Application No.	2023/90738
Proposed Development:	Demolition of existing dwelling and erection of detached dwelling with integral garage
Location:	33, Owl Lane, Shaw Cross, Dewsbury, WF12 7RG
OS Map Reference	SE 426309.9352 422959.8351
Applicant/Agent:	Architecture 1B
Class:	Minor Developments

**Consultation Response from KC,
Highways Development Management**

2023/90738 33, Owl Lane, Shaw Cross, Dewsbury, WF12 7RG

Demolition of existing dwelling and erection of detached dwelling with integral garage

Site Block Plan 1:500

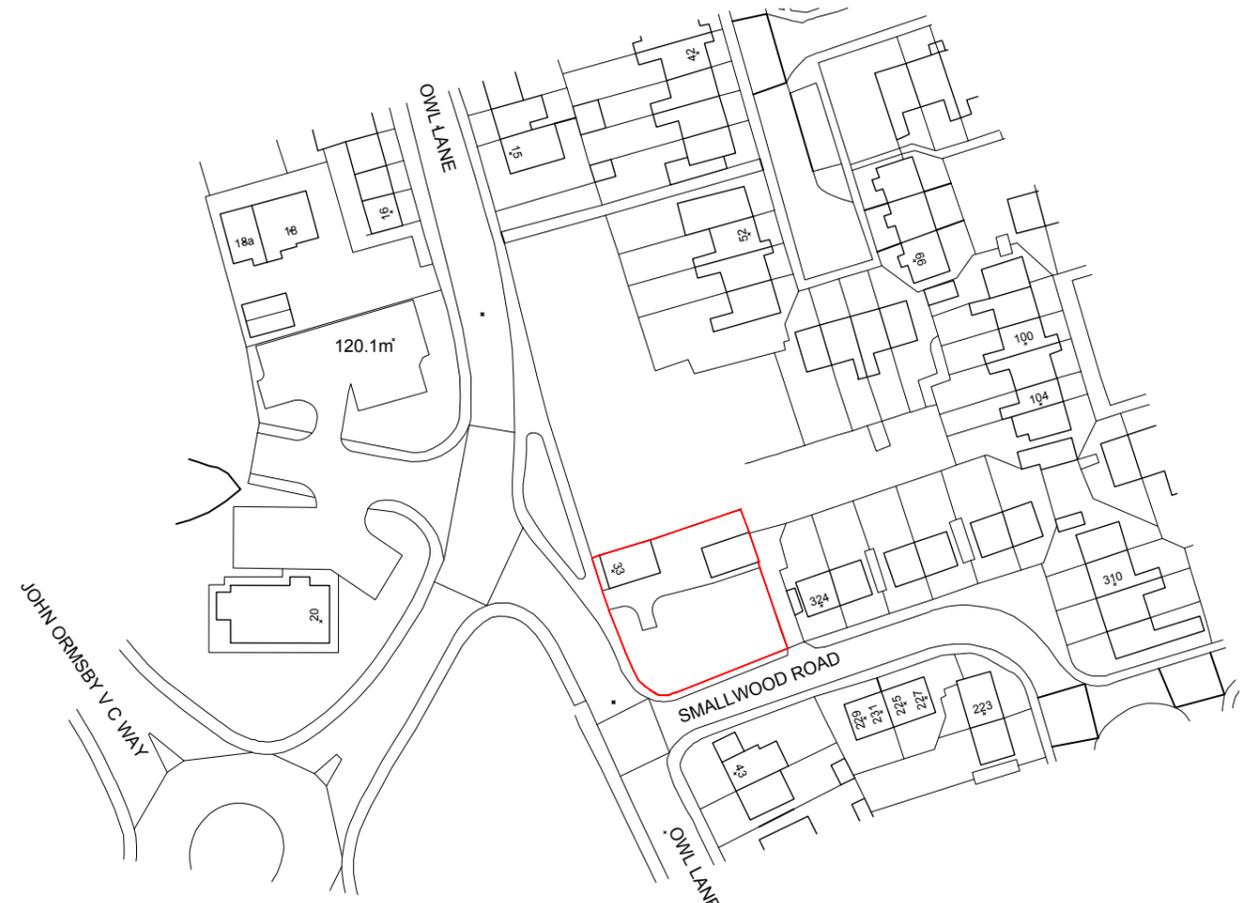
HDM would however recommend that the driveway is widened to allow space for a bin collection point at the site access to allow bins to be presented on collection day without obstructing the footway along this section of Owl Lane.
